**42 Honeysuckle Drive (SSD 10378)
Request for Additional Information**

Attachment 1 – Additional information requested by DPIE

DRAWING TITLE		JOB NUMBER	
STRUCTURAL DRAWING FOOTING PLAN		NL171278-04	
DRAWING NUMBER	REVISION	DRAWING NUMBER	REVISION
S02.01	3	S02.01	3
DRAWING SHEET SIZE = B1

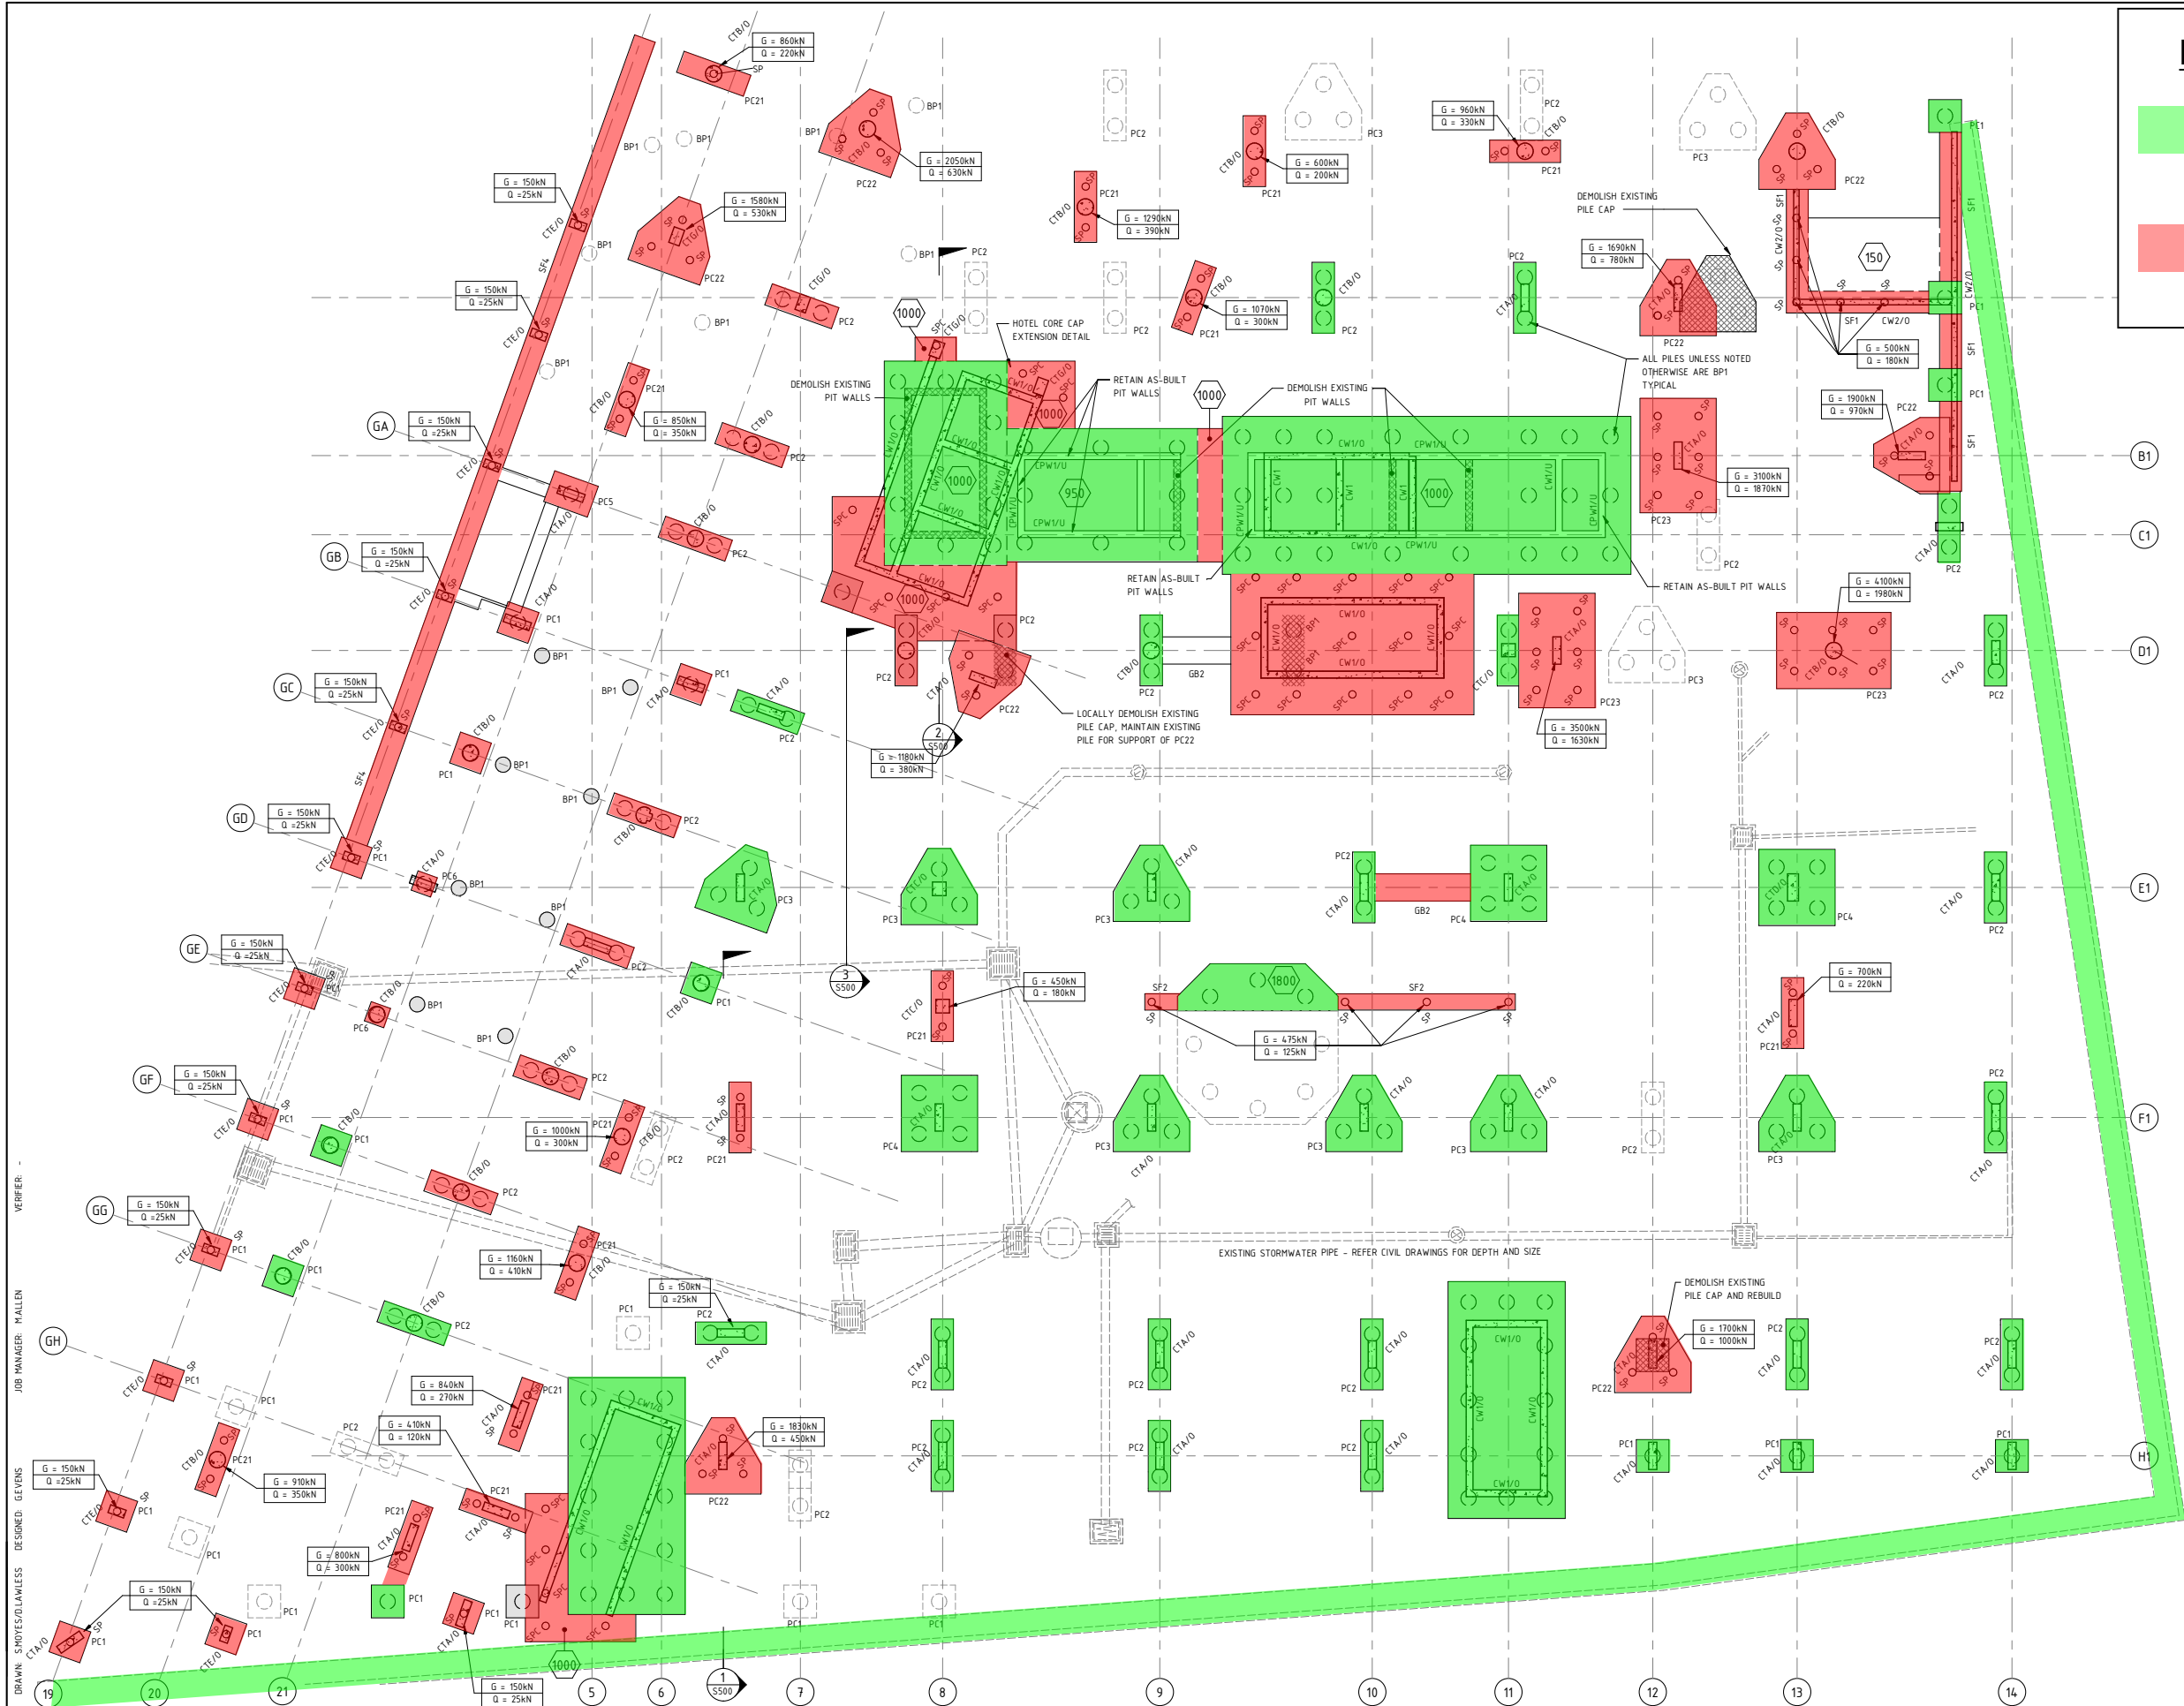
- The EIS notes that most of the required earthworks have been already completed at the site under SSD 8440 due to the required excavation being 'near replica'. However, it is unclear exactly what works are being undertaken consistent with the approved development and what works are being undertaken as part of your current proposal.
- Please provide a detailed section plan that clearly demarcates the excavation works that have been completed under SSD 8440 and the works proposed under SSD 10378. Outline and explain any differences between the excavation required for SSD 8440 and SSD 10378.
- Outline in detail how the structural basement works approved and being undertaken are able to be relied upon for the construction of a building above that has a different design, use, layout and configuration.

Figure 5 – Height Exceedance (Source: Bates Smart)

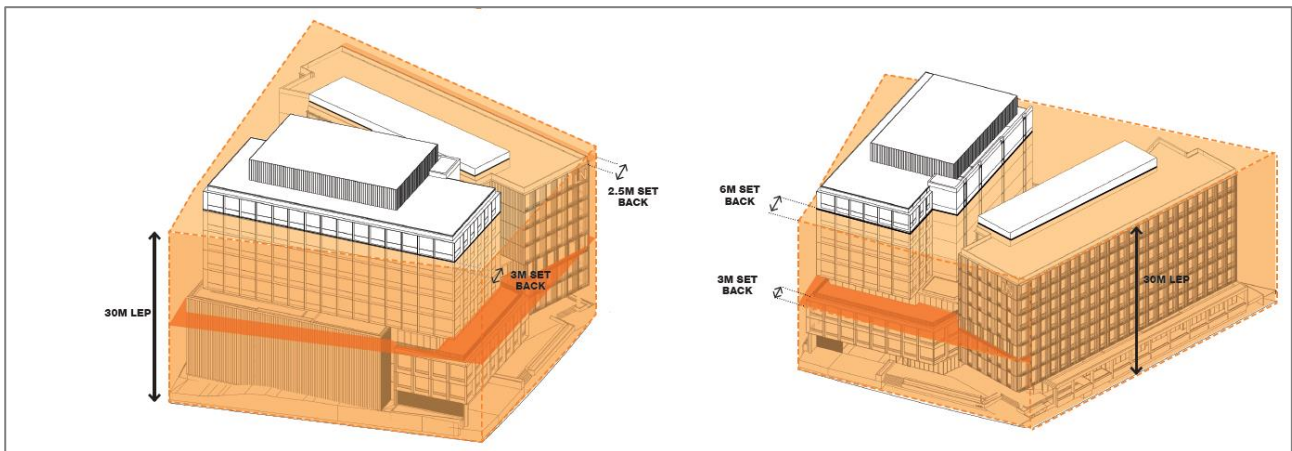
- The proposed development has a maximum building height of 38.83 m representing a 29.4% variation from the 30 m building height control in the NLEP 2012. This is significantly greater than the approved development which had a maximum height of 32.83 m representing a 9.49% variation from the building height control.

- The Department has reviewed the attached Clause 4.6 variation request and considers that a proposed variation of almost 30% is significant and should be reduced as the building's bulk and scale is excessive and would result in adverse overshadowing impacts on properties to the south and east of the site and would impact on views from 25 Bellevue Street, Newcastle. Further, the Department notes the Government Architect's office have raised concerns with the proposed height.

- The Department therefore requests the maximum height of the building be reduced so that it consistent with the maximum height approved under SSD 8440.

Figure 7 – Winter Solstice – June 21 Shadow Diagrams (Source: Bates Smart)

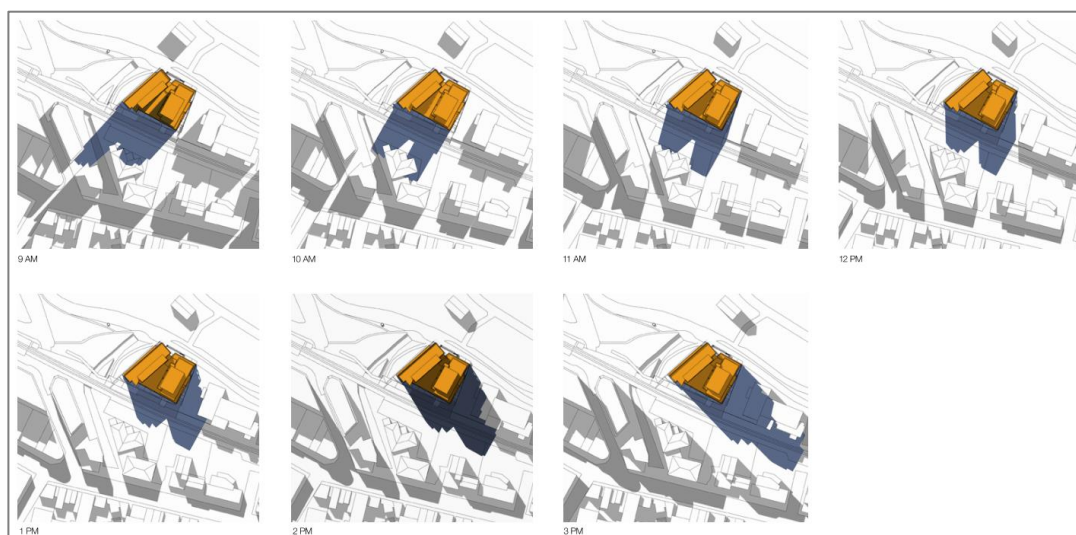
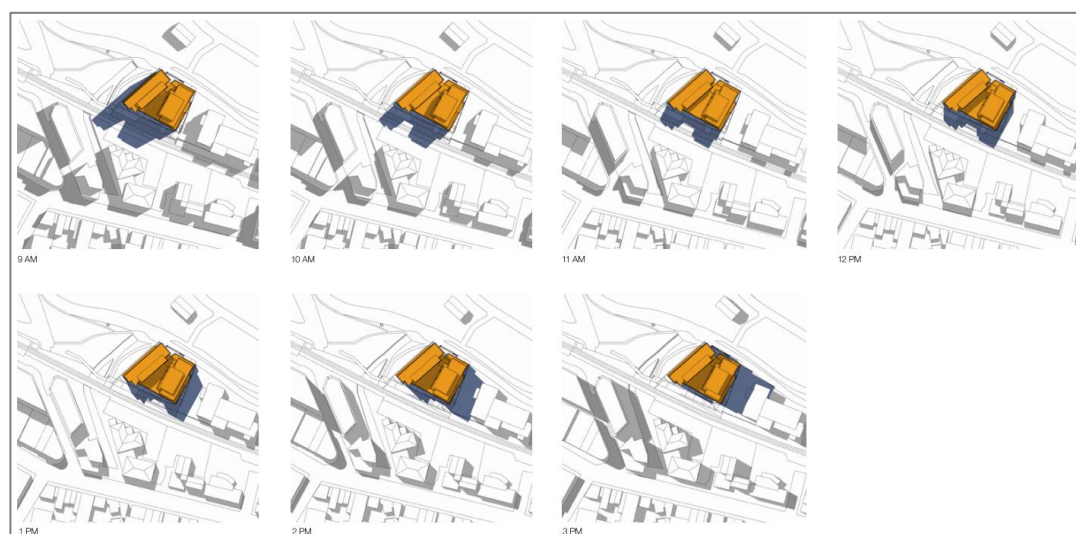
- Please provide updated shadow diagrams (as amended by point 1 above) that compare the shadow impact resulting from the proposed development with the shadow impact resulting from the development approved under SSD 8440.
